**Vickery Extension Project Response to Submissions (RTS)  
Crawford review for DPIE consideration  
Section 6.4 Flooding**

*Ken Crawford  
Retired Hydrogeologist  
Former Principal Consultant  
KLC Environmental Pty Ltd  
13<sup>th</sup> September 2019*

This review is concerned with the **location** of the coal handling and preparation plant (CHPP), train load-out facility and rail spur line. Project RTS pages 50-70.

Figure 5 | Project Rail Spur Line and Borefield

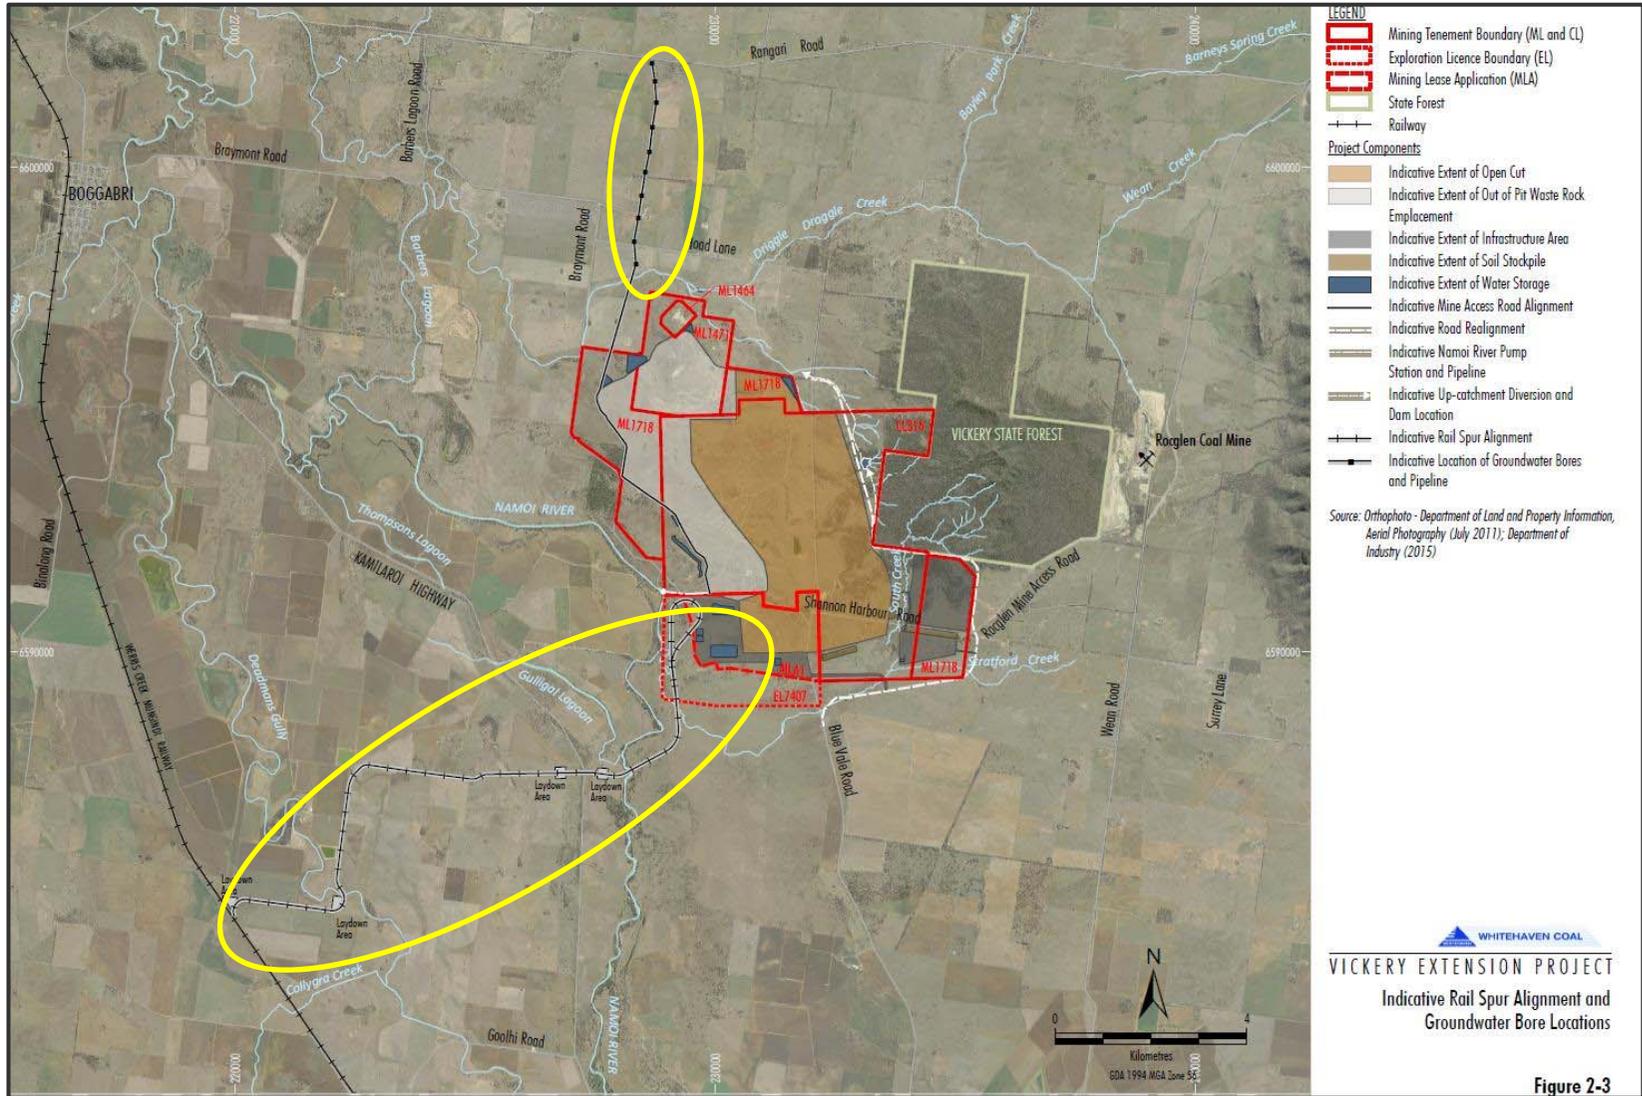
Rail spur **location** must be assessed in the spatial context of our ‘confined floodplain’. The Project mapping clearly shows that the CHPP, train load-out facility and rail spur are far too close to the Namoi River. The river and Gulligal Lagoon ecology will be under threat. The Namoi River must remain connected to its floodplain.

Rail viaduct bridge location necessitates a near straight line across the floodplain. The Project alignment indicates two right angle bends and diagonal sections to the flood flow. As well as creating engineering difficulties, this design location is the worst case scenario for illegal diversion of water; soil erosion control and aquifer recharge interference.

Figure 8 | Namoi River Flooding in the 1% AEP Event

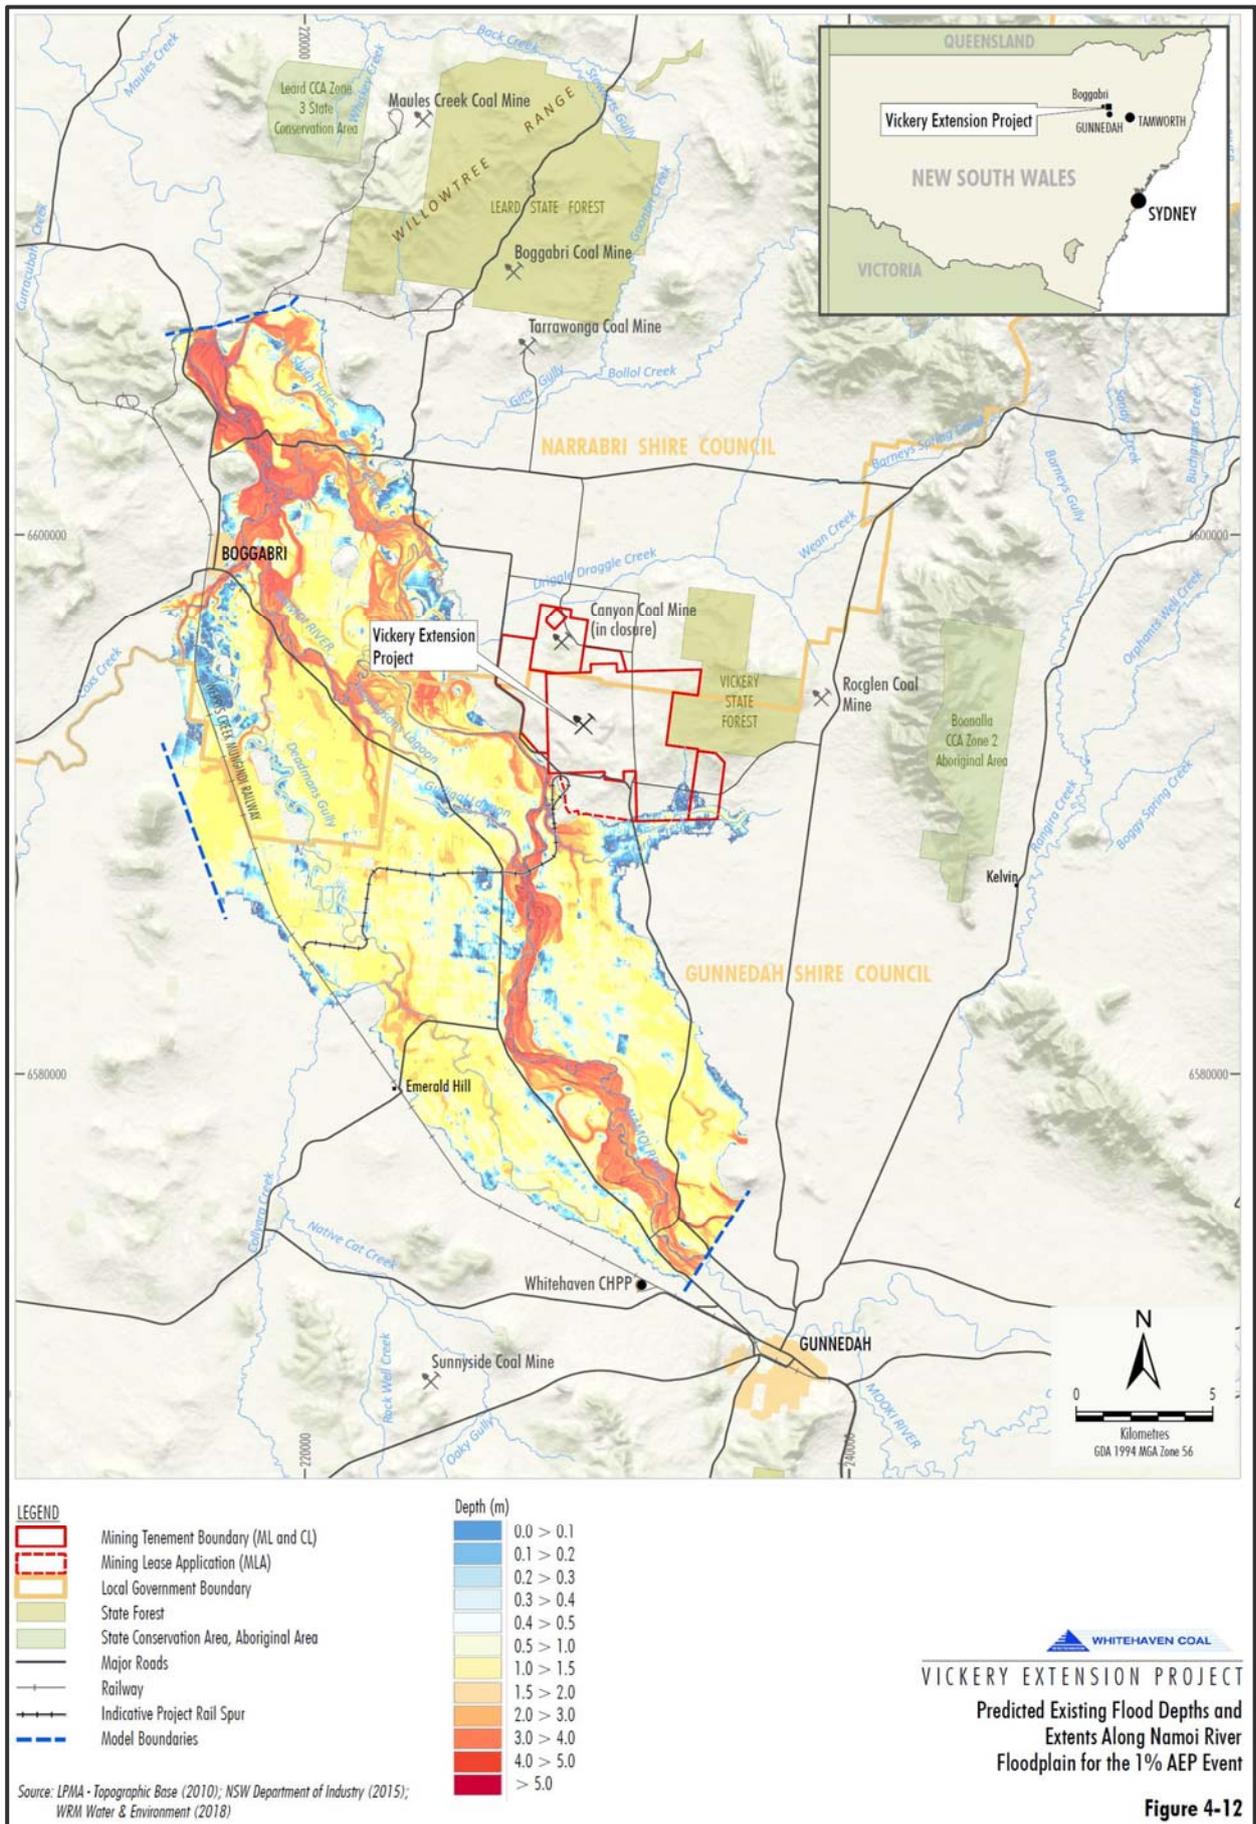
Transient numerical modelling cannot be relied upon to predict extreme flood events in this catchment area. By definition they are 'extreme' precisely for the reason that they exceed previous floods by an unknown magnitude. The unknown unknowns, if you like. Sensitivity studies using percentages and probabilities of exceeding potential maximum floods does not adequately address future flooding in our days of extreme weather events.

Rangari Creek is left out and also the significance of Cox's Creek flooding and the bottleneck at the Gins Leap Gap. Restricted boundary modelling always has these limitations and the scope of modelling should have been extended. Extreme weather events in the future will make the discharge of Cox's Creek and the constriction at the Gap even more important and Rangari Creek should never have been left out.
